## CITY OF MERCER ISLAND

WFC21-036 Review

January 4, 2022

RE: WCF21-036, 8215 SE 78<sup>th</sup> St

SHEET TITLE: POLE ELEVATIONS  
 SHEET NUMBER: A1.2  
 PAGE: 3 OF 7  
 PLOT SCALE: 1:1 @ 24"x36"; 1:2 @ 11"x17"

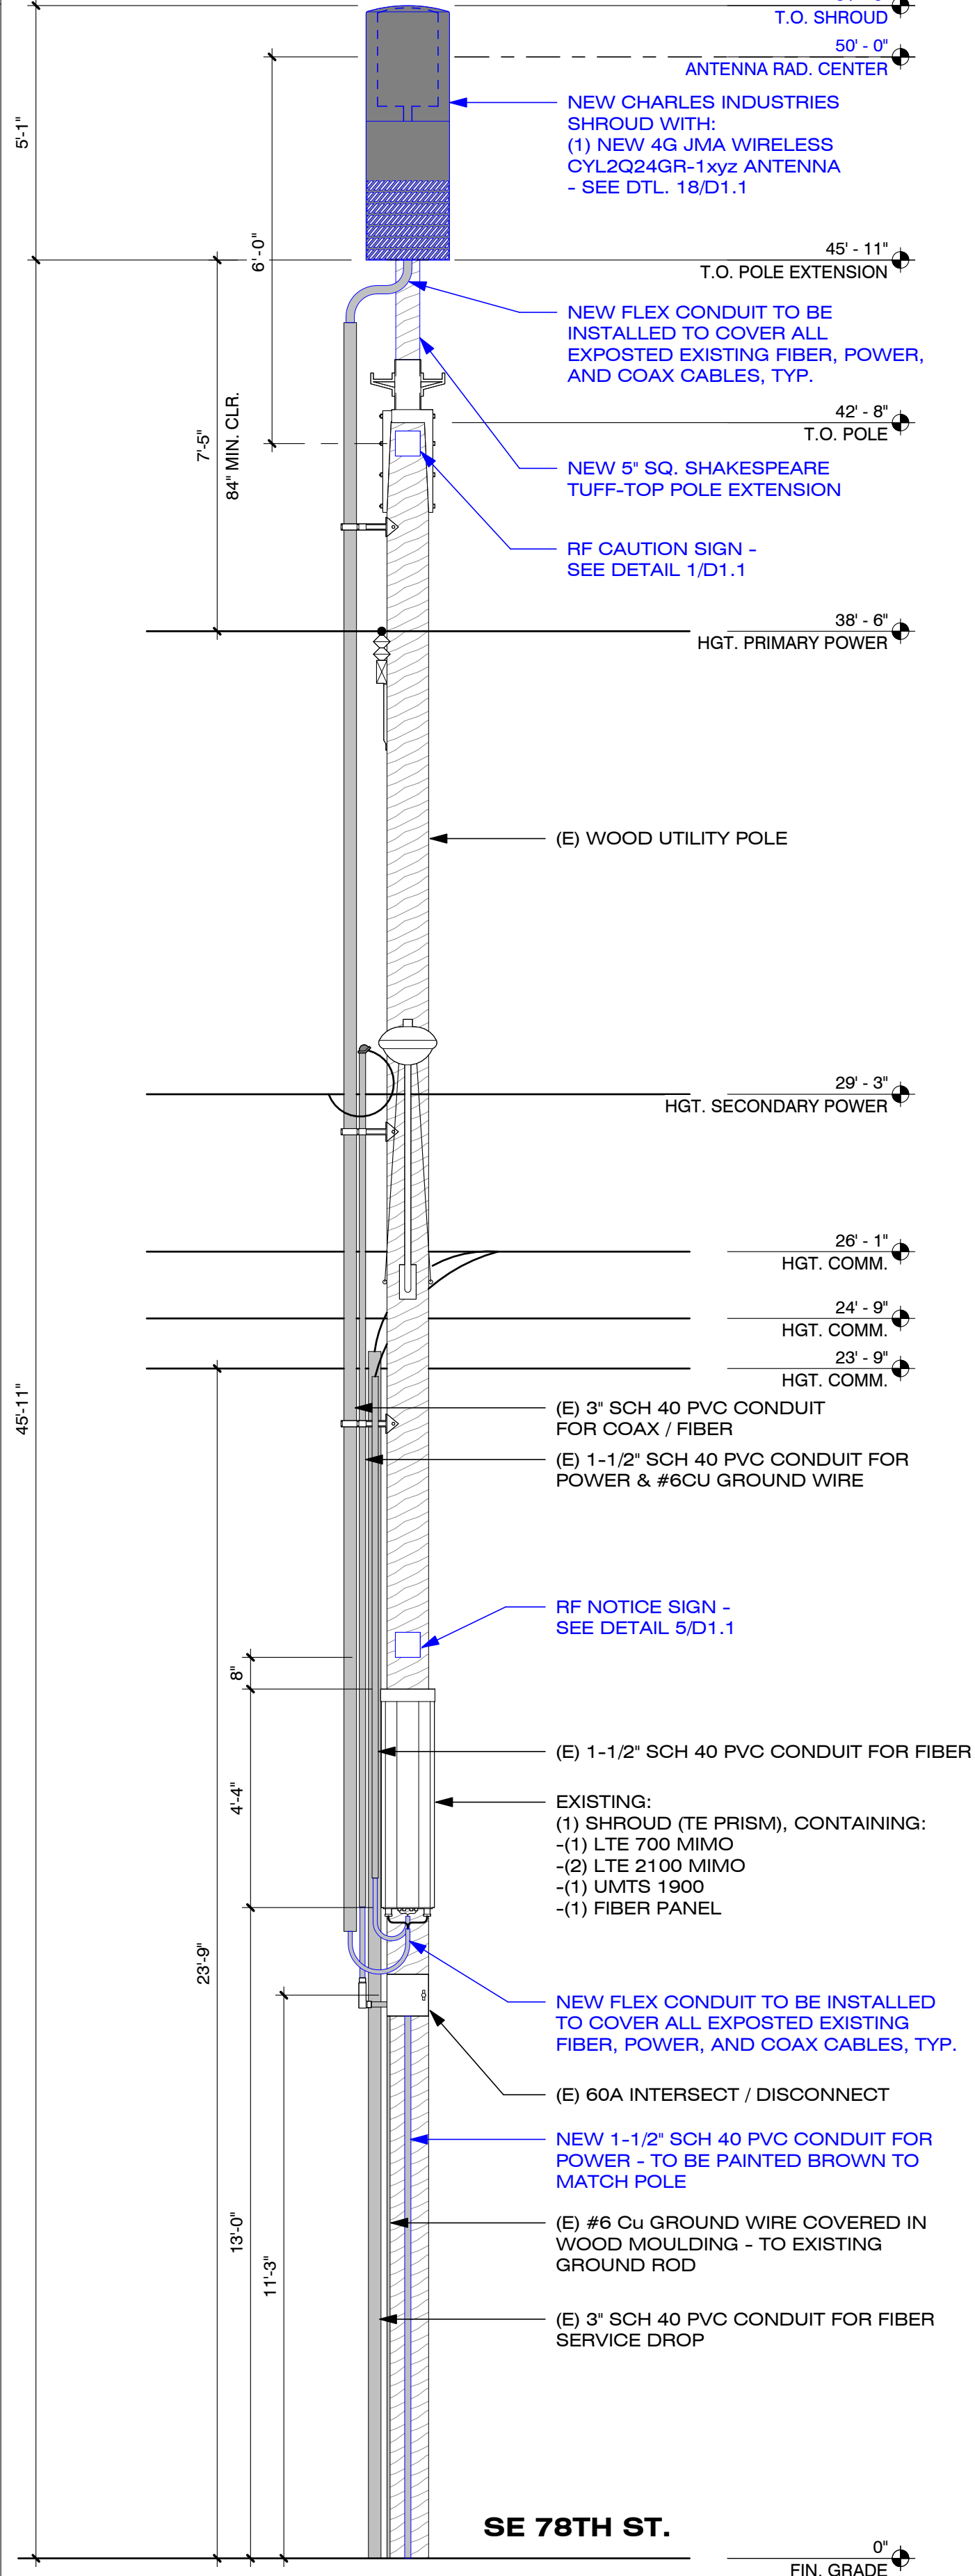
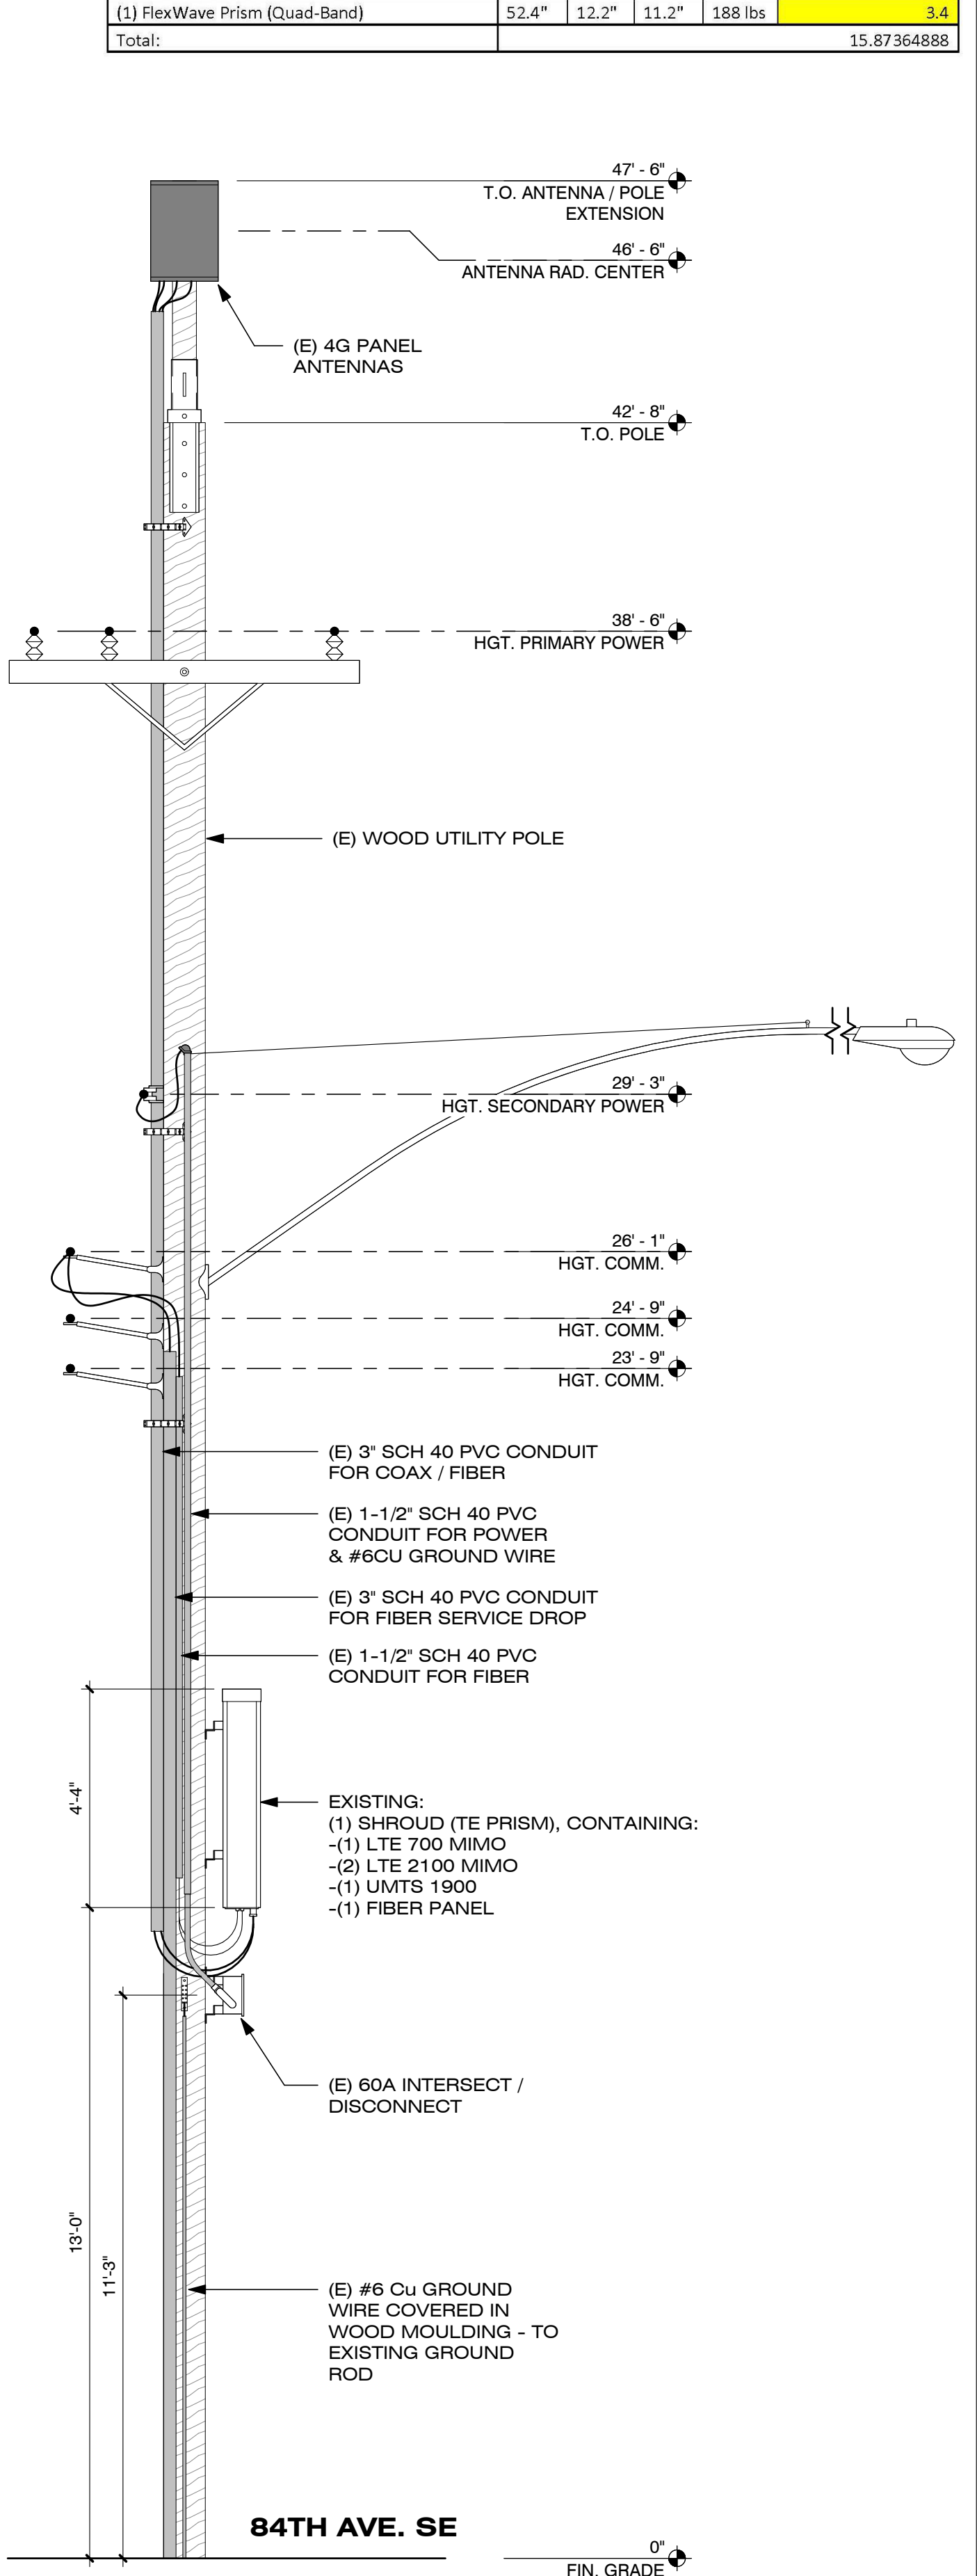
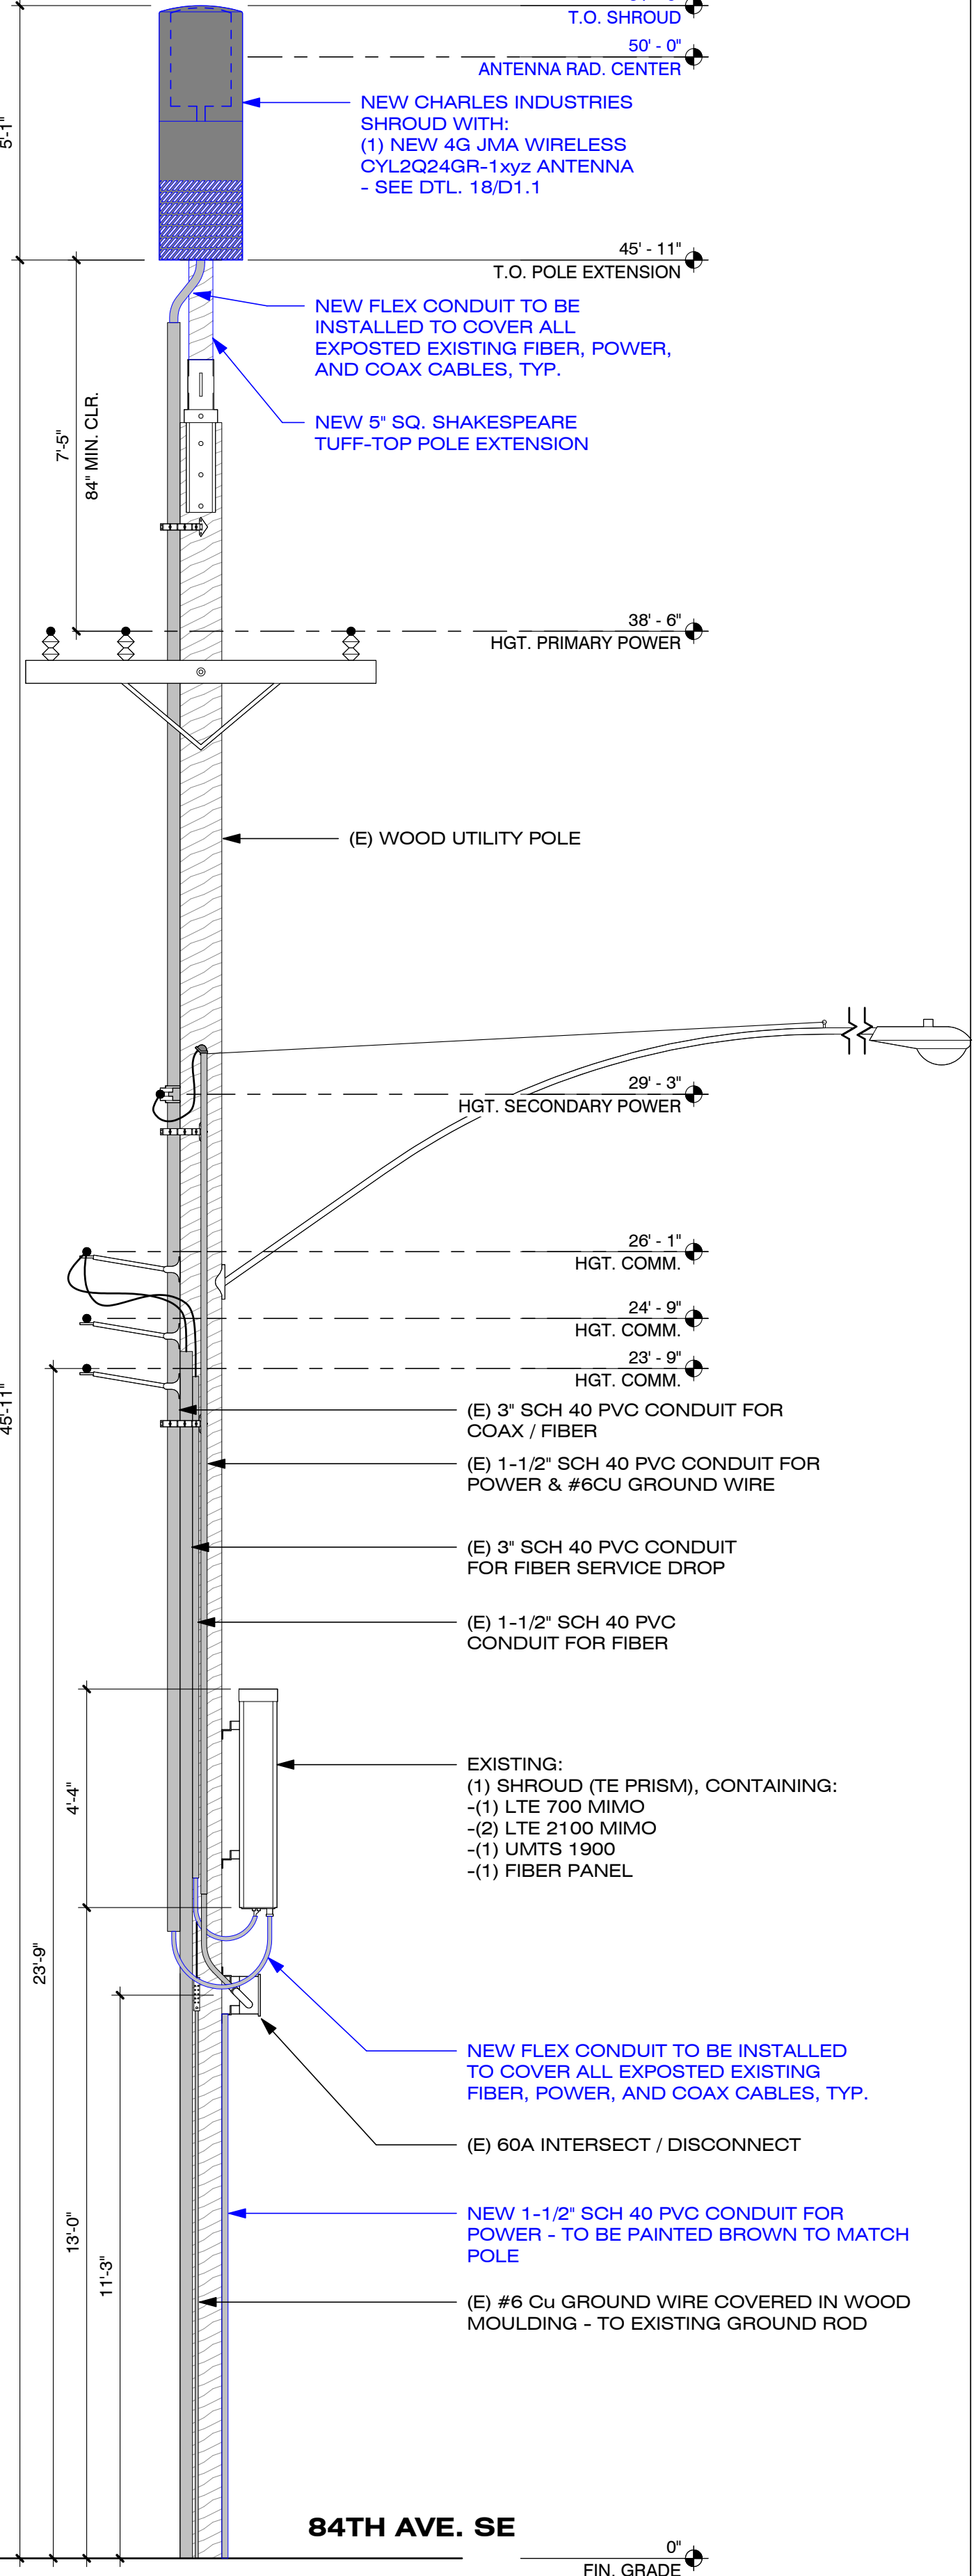
2. MICC 19.06.075(A)(1) states that ground-mounted equipment in the rights-of-way is prohibited unless such facilities are placed underground or the applicant can demonstrate that pole-mounted or underground equipment is infeasible. If ground-mounted equipment is necessary, then the applicant shall submit a concealment plan pursuant to MICC 19.06.075(G). In the new application for a modification to an existing small cell facility, please revise the location of the equipment cabinet so it is not ground mounted or provide a concealment plan for the cabinet consistent with MICC 19.06.075(G).

3. MICC 19.06.075(C)(13) requires all cables and wires to be routed through conduit along the outside of the pole. The provided plans show that the facility's wires are proposed to be exposed between the top of the main conduit and the antennas and between the bottom of the main conduit and the equipment cabinets. In the new application for a modification to an existing small cell facility, please revise the plans to show that all cables and wires will be contained within conduit from the antennas to the equipment cabinets.
